**Submission – Mosman High School redevelopment (SSD – 10465)**

I am writing in response to the Department's exhibition of the State Significant Development Application Number – 10465, for the redevelopment of Mosman High School located at 745 Military Road, Mosman.

Figure 2 – Façade Palette
Source: Woods Bagot

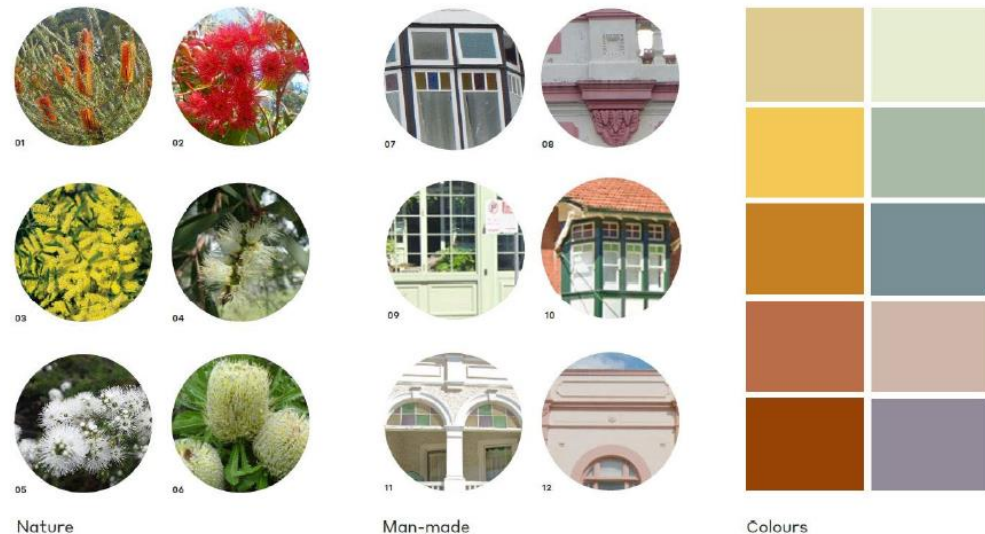
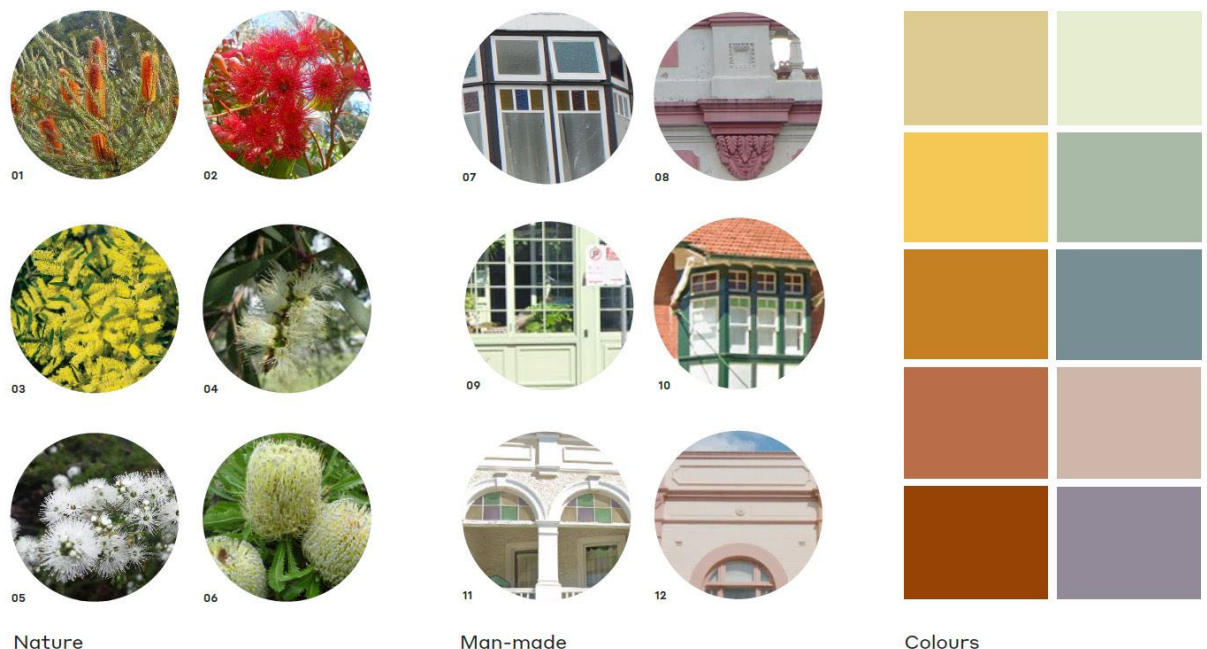
1. An archival recording should be made of the buildings proposed to be demolished and lodged with Council's Local History Library;
2. In terms of the colours facing the Military Road Heritage Conservation Area, it is recommended that the window surrounds facing Military Road be more muted. Brighter colours facing away from Military Road may be acceptable.
